CITY OF ALBUQUERQUE

Re: Ronald McDonald House, Engineer's Stamp dated 4-2-07, (J16/D18)

RE: Ronald McDonald House Expansion (J16/D18)

Re: Ronald McDonald House Expansion, Engineer's Stamp dated 3-8-07, (J16/D18)

C-101

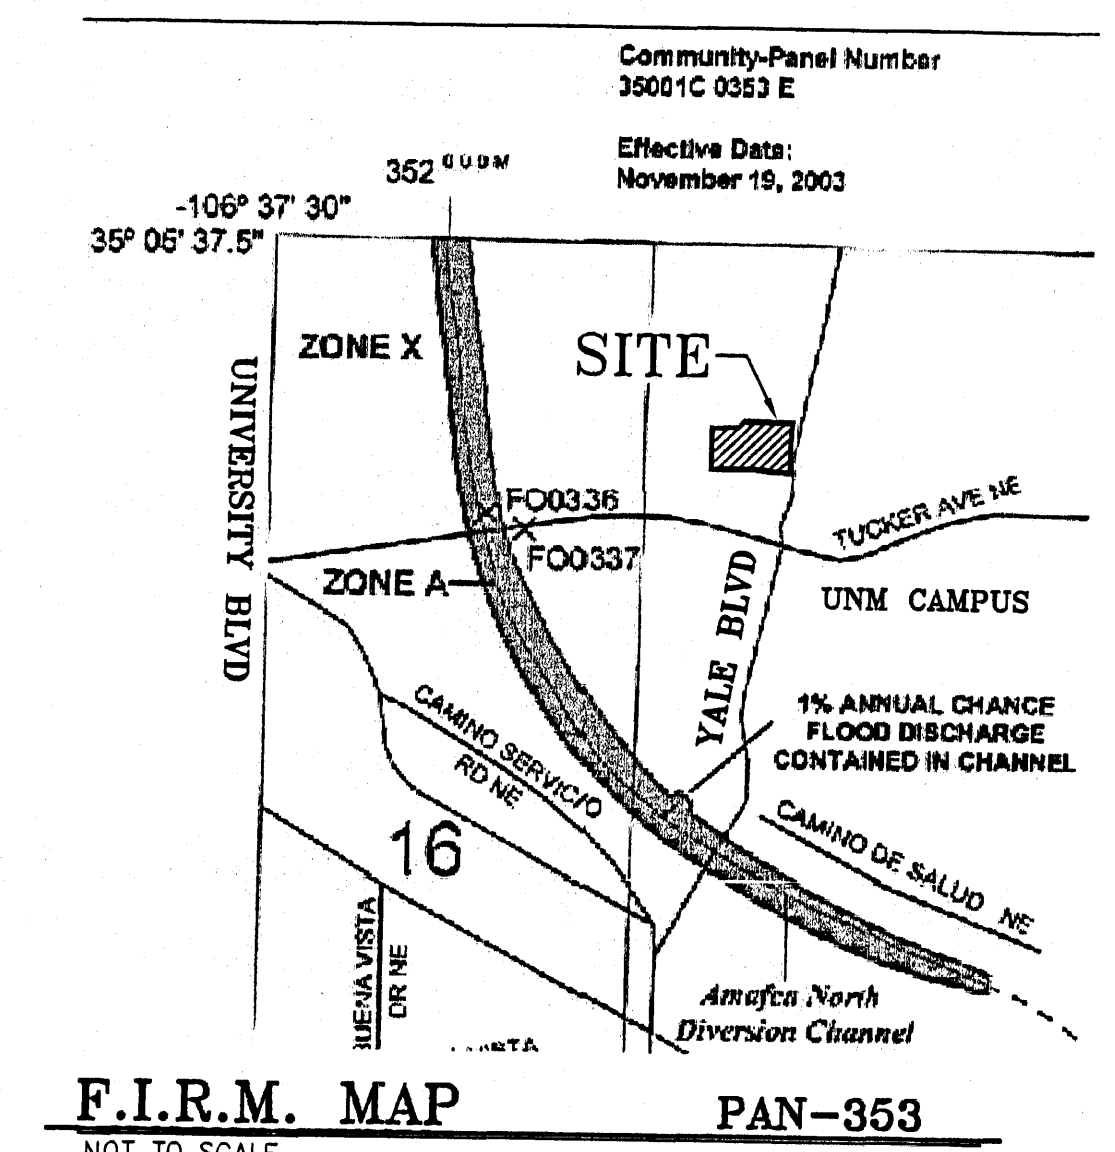
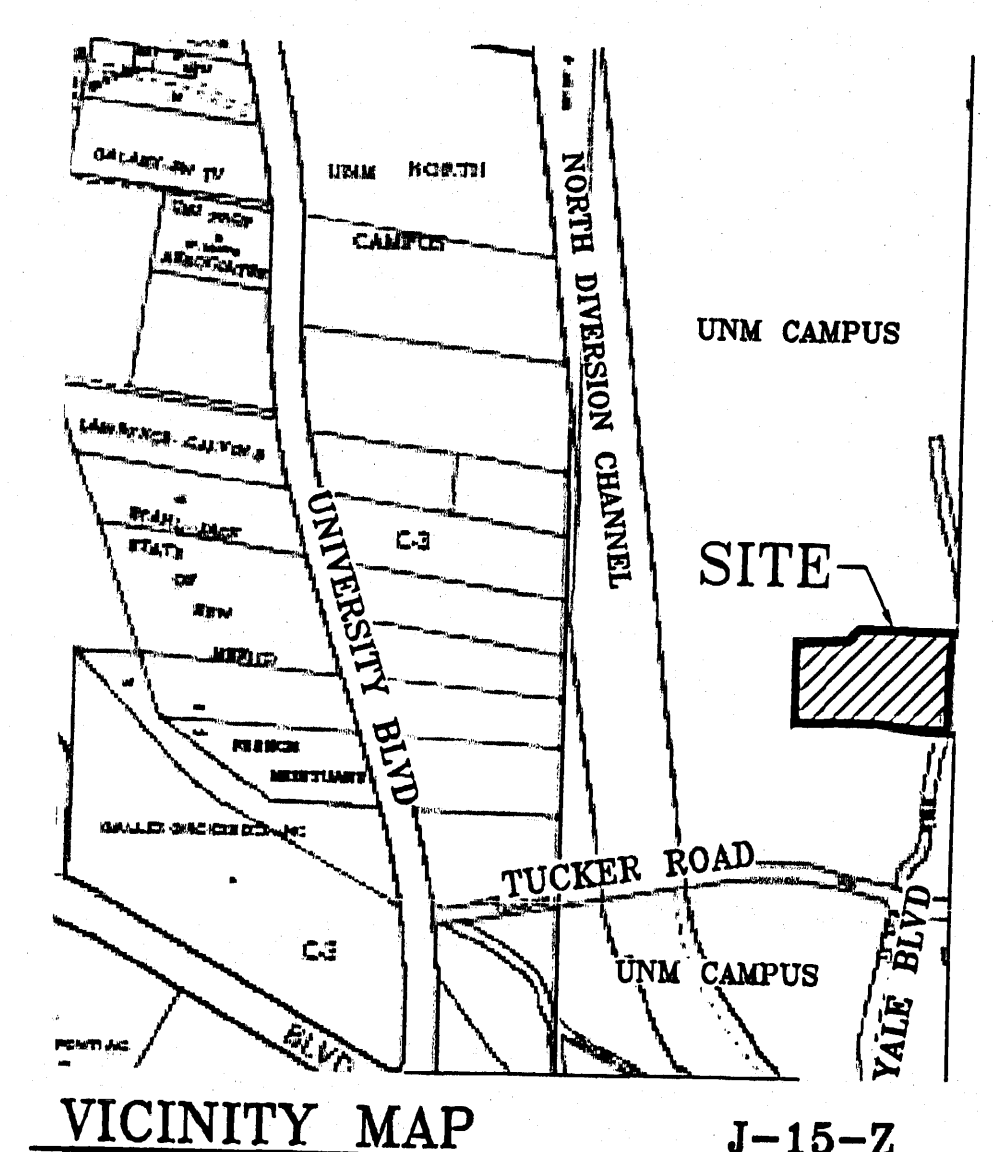
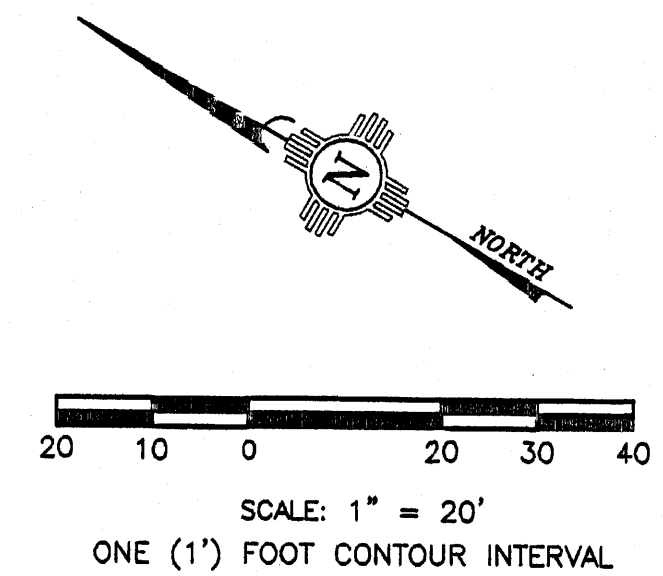
1. Please cite and / or include the appropriate F.I.R.M. panel and state whether or not the subject site is located within a designated flood plain.
2. Please reference the permanent benchmark from which the temporary benchmark parameters were derived.

3. The land treatments proportions under "Proposed Development" add to 115 percent. It appears that these values are intended to refer to the actual acreages, not percentages. Is the total site area 1.07 acres, 1.077 acres, or 1.15 acres? The plan is inconsistent on this point.

4. There is no land treatment 'A' under developed conditions.
5. There is no standard drawing 2106 as referenced in keyed note 3.
6. Your keyed notes" 1 and 2 refer to standard drawings 2415B and 2415A for standard curb and header curb respectively. Drawing 2415A is for standard curb and gutter and 2415B is for header curb.

1. Comment #1 - the F.I.R.M. panel has been included on Sheet C-101, the proposed project is not within a designated flood plain.
2. Comment #2 – a permanent benchmark has been referenced as shown on Sheet C-101, keyed note #8.

3. Comment #3 – the land treatment percentages under “Proposed Conditions” have been revised to depict actual percentages rather than acreages. The total site area is 1.15 acres as referenced under existing and proposed conditions.

4. Comment #4 – the land treatments for the hydrology calculations have been revised to reflect no area in land treatment “A” under fully developed conditions as shown on Sheet C-101.

5. Comment #5 – keyed note 3 has been revised to reflect the correct number, which is City of Albuquerque Standard Drawing 2206 as shown on Sheet C-101.

6" CONCRETE CURB AND GUTTER DETAIL  
SCALE: NONE

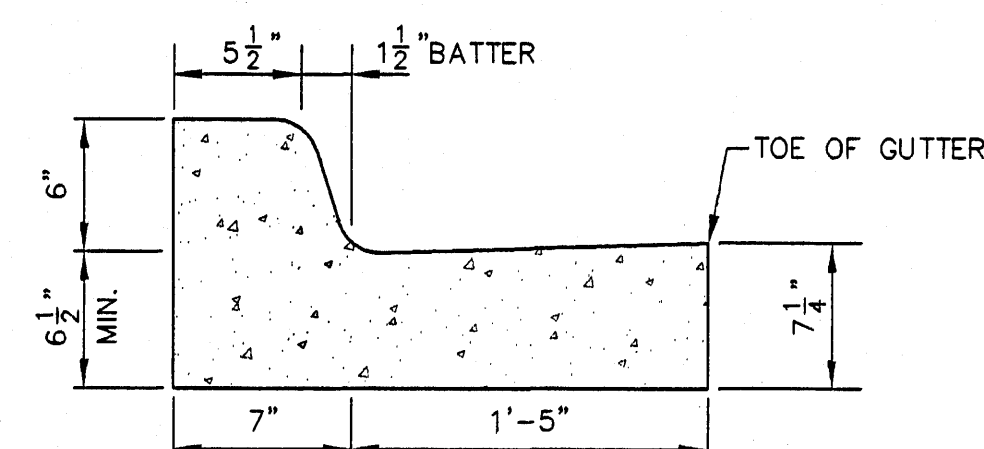
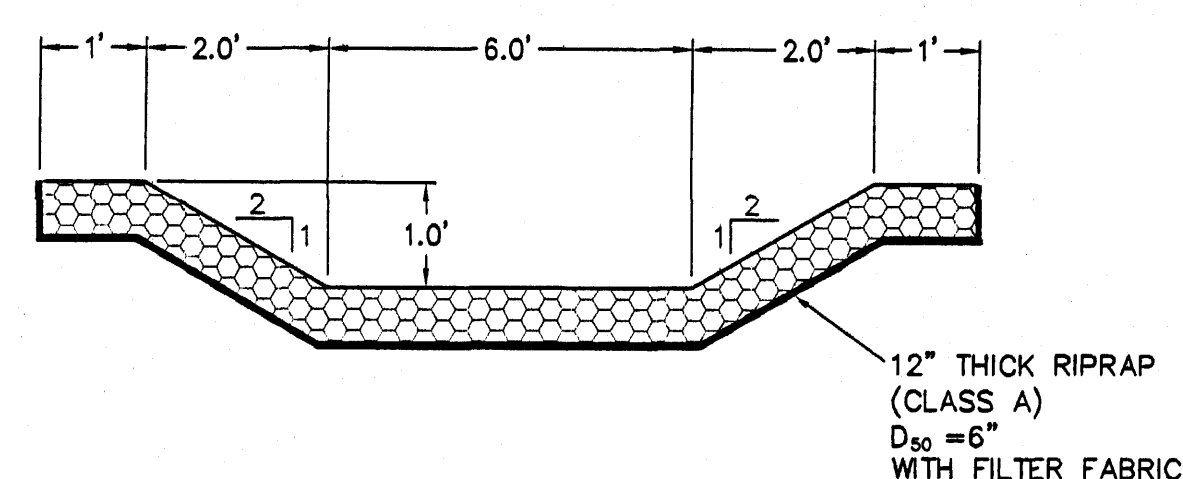
7. The spot elevations given for top of curb and flow line indicate that 6-inch curb is desired. Standard curb (2415A) has an 8-inch rise. Please either revise the curb / flow line spot elevations, or eliminate the reference to standard drawing 2415A and provide a cross section detail for the proposed curb and gutter elements.

6. Comment #6 – keyed note 1 has been revised and references a standard curb & gutter detail as shown on Sheet C-102. Keyed note 2 has been revised to reflect the correct standard drawing number as shown on Sheet C-101.

7. Comment #7 – a 6-inch standard curb & gutter detail has been added to Sheet C-102, the City of Albuquerque standard curb & gutter is no longer referenced in keyed note 1, Sheet C101.

SPILLWAY DETAIL  
SCALE: NONE

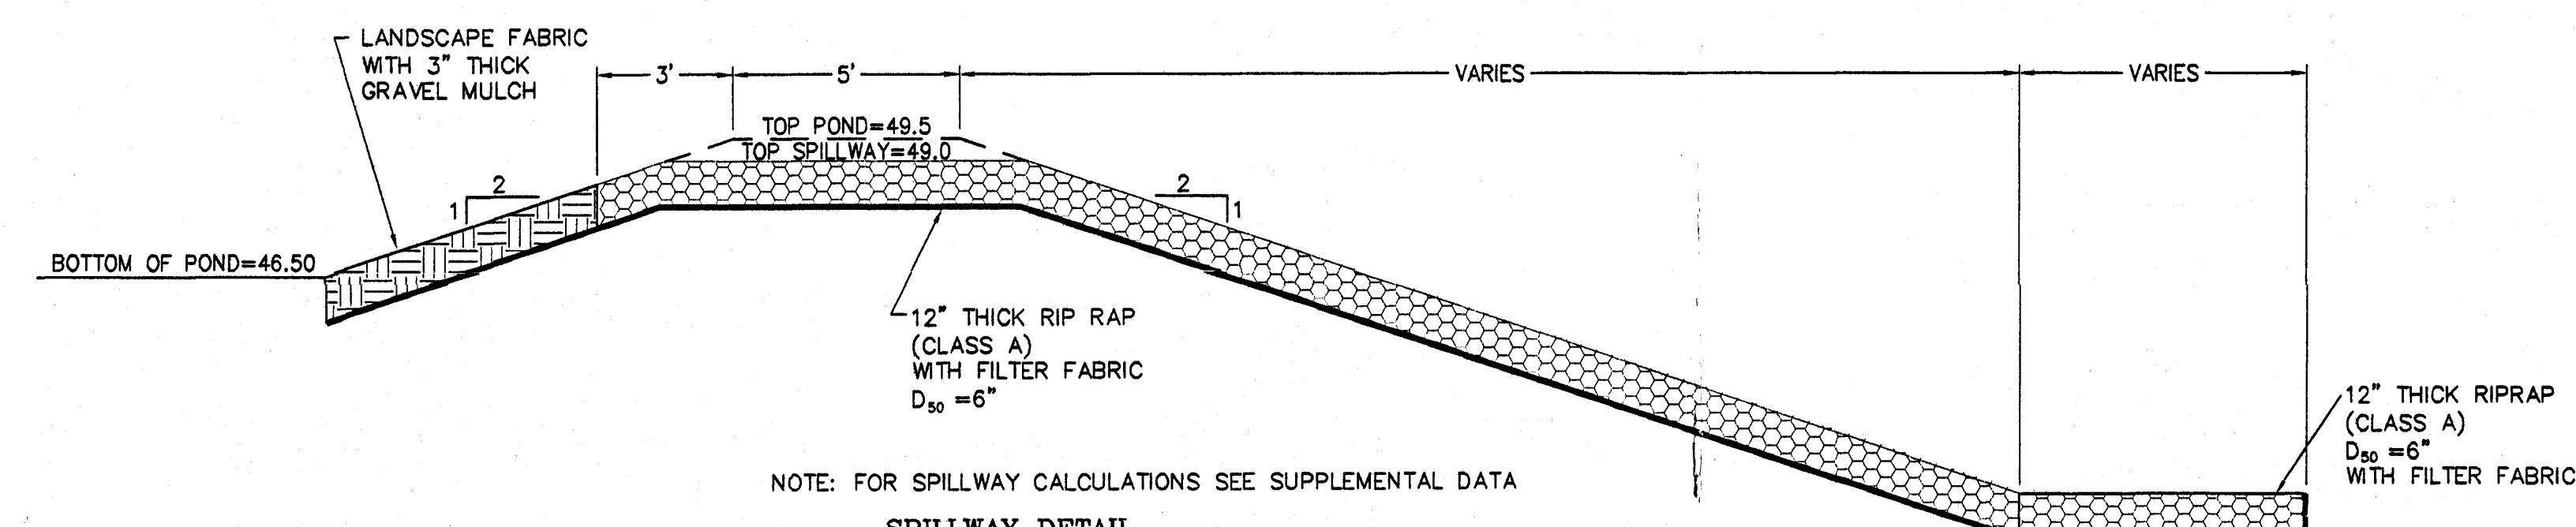
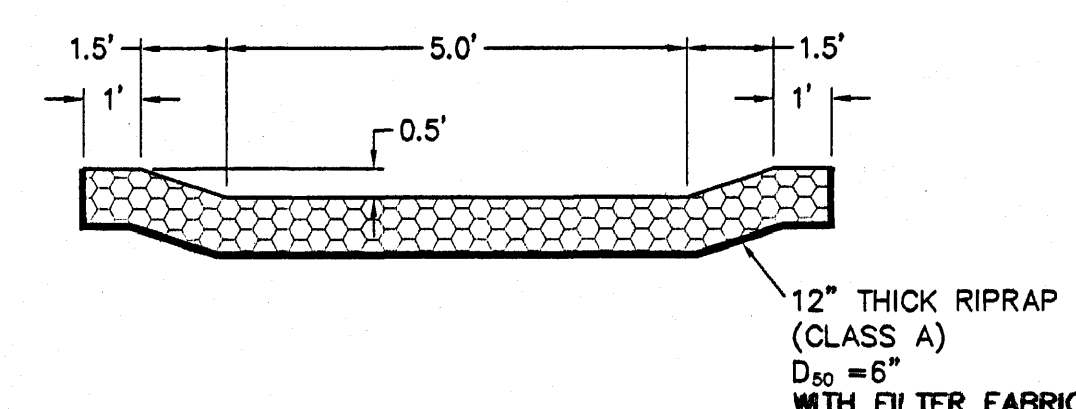
3. I could not tell from the drawing attached to the email how the onsite detention pond was draining. AMAFCA recommends some riprap on the pond overflow section and in the arroyo for a short distance downstream.
